Statement of Common Ground with Wiltshire Bridleways Association (Tracked)

Revision **~~1~~2**

Planning Inspectorate Reference: EN010168

Document Reference: EXAM/8.17

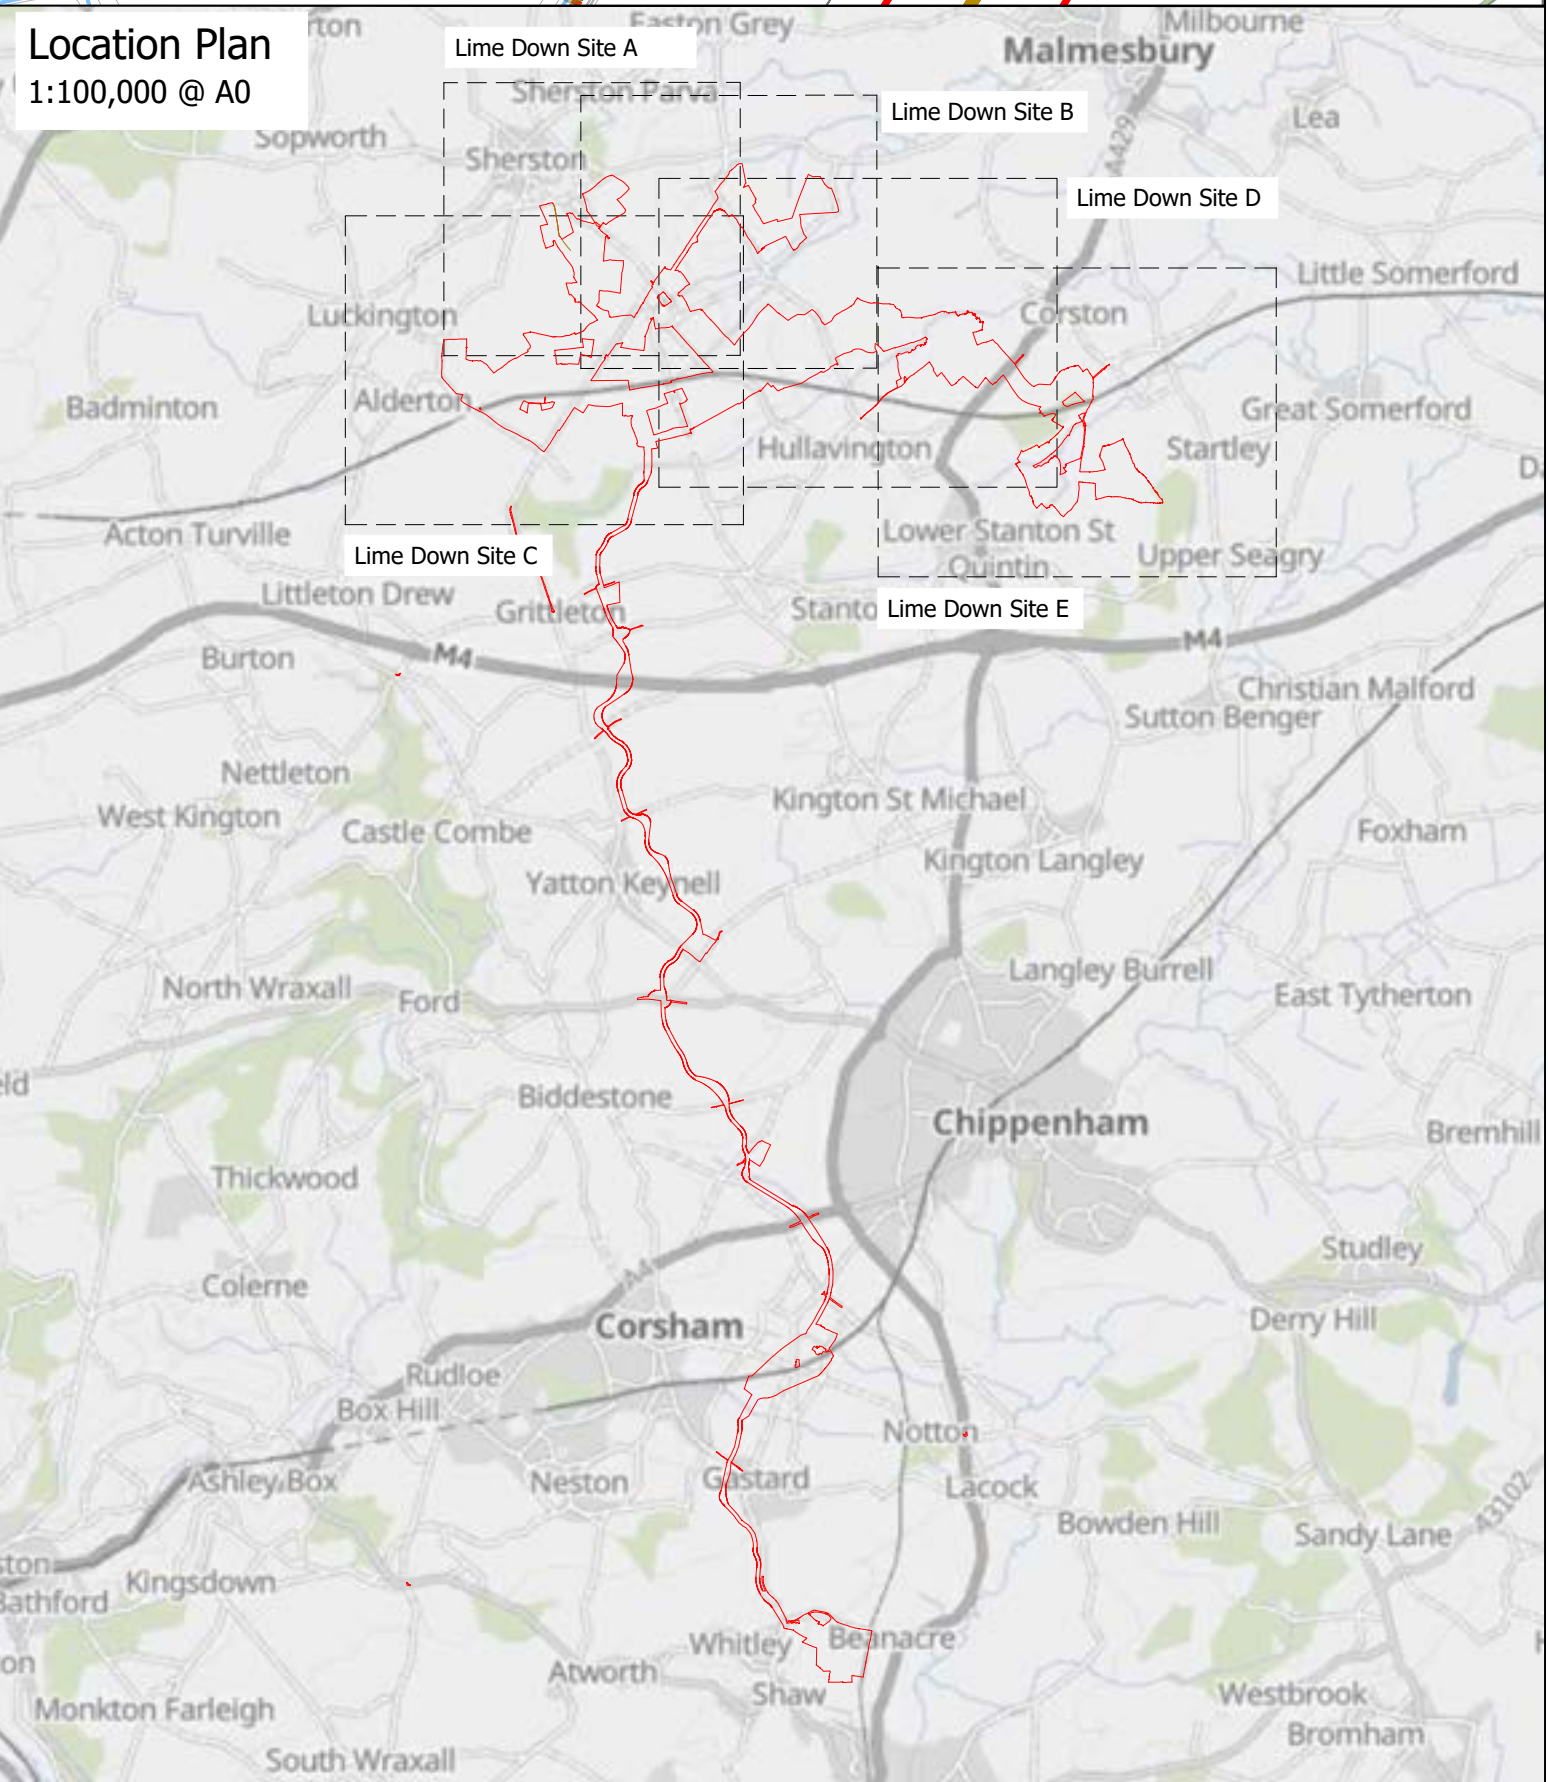
3.1.11	Mitigation - Fencing	WithoutThe WBA would like the below mitigation measures WBA objects to all parts of the development. • Maintain minimum <u>path</u> width of 4-5m along bridleways/byways. • Use open meshto follow British Horse Society guidance at 3 metres and for fencing; avoid intimidating or hazardous fencing (e.g., metal palisades with spikes). • Ensure to be of vegetation and hedges do not narrow usable paths.	A minimum surface width of 3 m is proposed for bridleways, as recommended by guidance from the British Horse Society. However, only groundcover planting will be planted immediately alongside PROWs, allowing users to pass at a greater width if required. Where new hedgerow planting is proposed alongside PROWs, this will be planted to maintain a suitable passable width that is to be determined at the detailed design stage. This is shown indicatively on ES Volume 2, Figures 3-4-1 to 3-4 5.2: Landscape and Ecology Mitigation Plan [REP-029 to REP1-032] .	Under Discussion

Reference	Sub-topic	WBA Position	Applicant's Position	Status
		It will be very important that the width of the corridors (especially on SHER 16 and the proposed permitted paths through the arrays) are wide enough so horses do not feel trapped or threatened. We note that a minimum of 3 meters is proposed narrower.	The majority of site fencing is to consist of 2 m deer stock fencing (<u>i.e. wooden posts with wire mesh</u>) set a minimum of 15 m from the centreline of the nearest PROW. Metal palisade fencing is only proposed in locations where there is a danger to life, and so is limited to substation and BESS enclosures. Palisade fencing is not proposed adjacent to PROWs. These principles (including offsets to PROWs, PROW widths, and fencing and PV types), are set out in the Design Principles and Parameters [REP1A-008] and indicatively shown on the ES Volume 2, Figures 3-4-1 to 3-4 5.2: Landscape and Ecology Mitigation Plan [REP-029 to REP1-032] All details of the Scheme are subject to the relevant Requirements in Schedule 2 the Draft DCO [REP1-007].
